Ref: WA/48/14/PL

Demolition of existing commercial buildings/garages and erection of 3 No 2 bed terraced dwellings along with provision of ancillary parking, turning and landscaping (re-submission of application WA/52/13). At Deans Yard Orchard Way Fontwell.

Proposed Site Layout

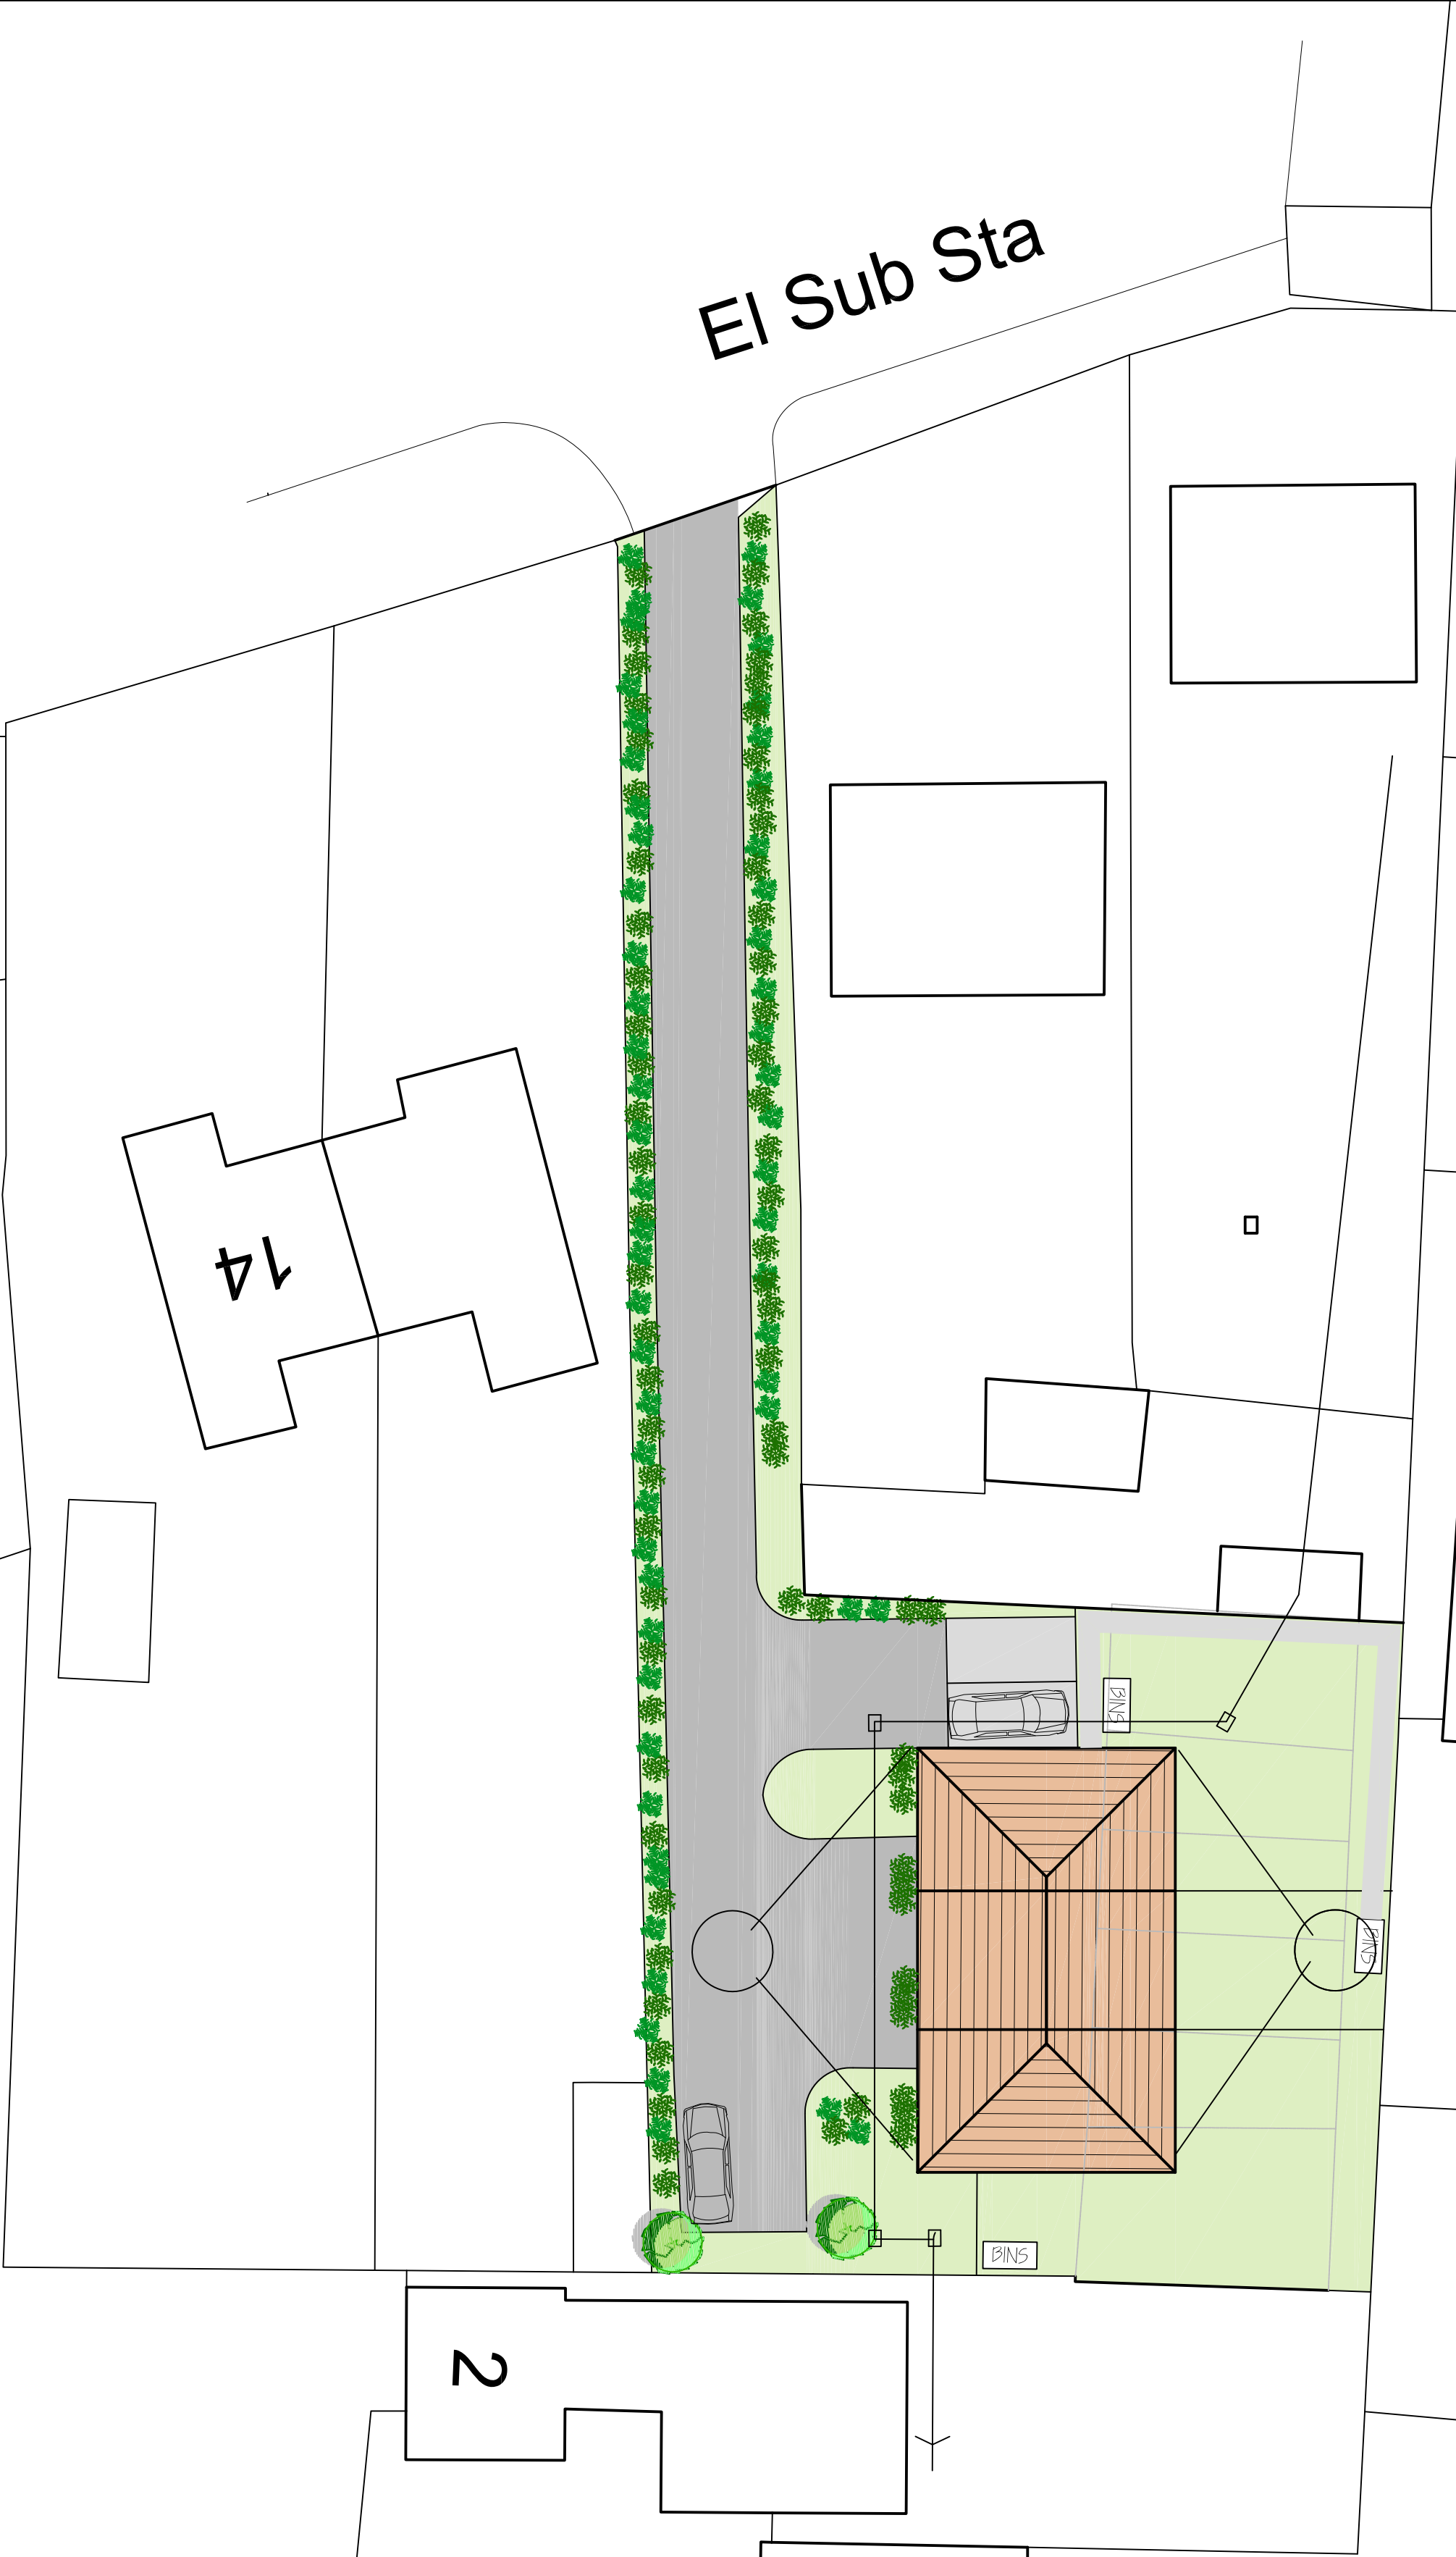
Whilst this application was for four houses the fact that the recent application is for three terrace houses does not change the fact that the development would be cramped and parking restricted.

The access road leading to the proposed development is in very poor condition with the surface crumbling and many potholes. Further deterioration of the surface could make our access to our garages difficult.

Collection of refuse is also another problem. To my knowledge the collection vehicle does not go down into the area proposed for the development, so the residents would have to bring their waste bins onto our road, which is not acceptable.

Emergency vehicles such as fire engines, dustcarts, and any other large vehicles would also be restricted by the insufficient area in front of the houses, as well as the narrow access road.

PROPOSED GROUND FLOOR LAYOUT PLAN

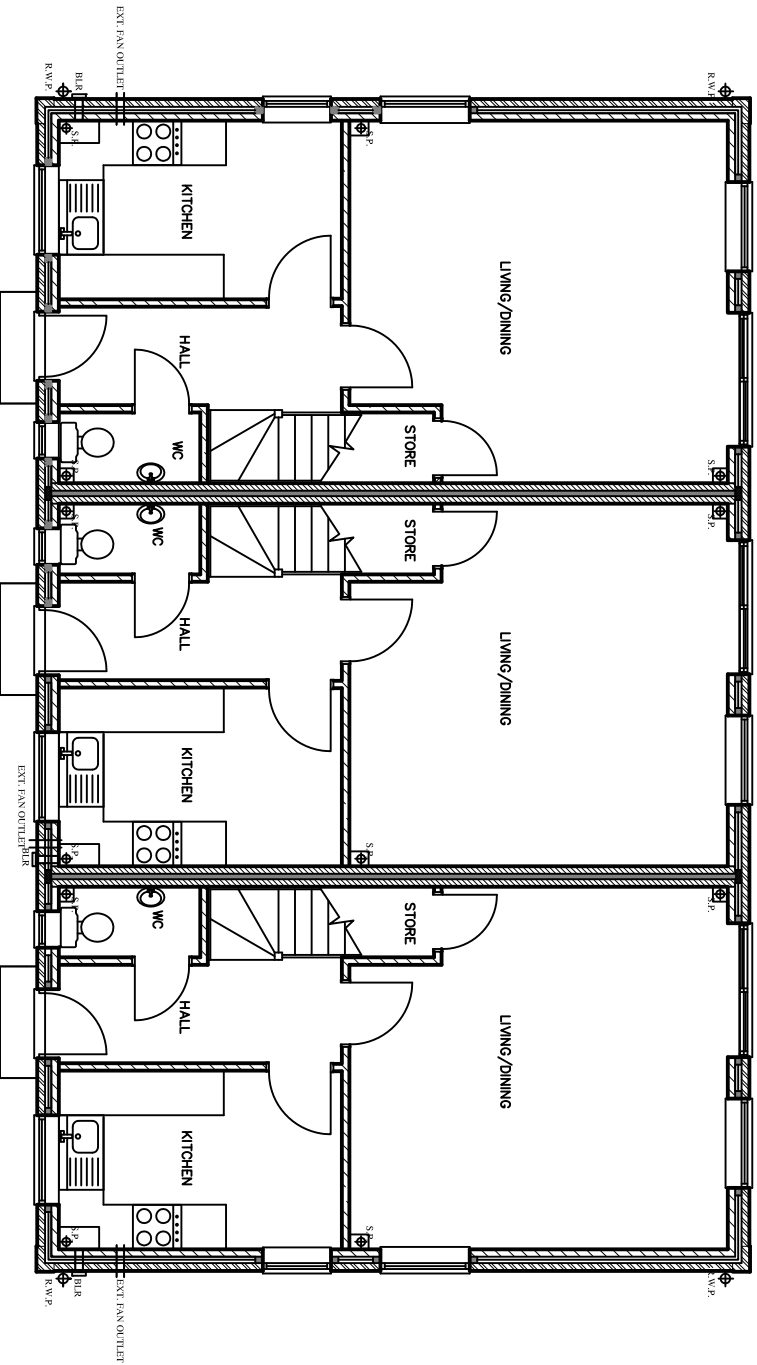
The plan of the first terrace house shows that it will be close to our property, and whilst there are no windows on the upper level it will be very close to our boundary and intrusive.
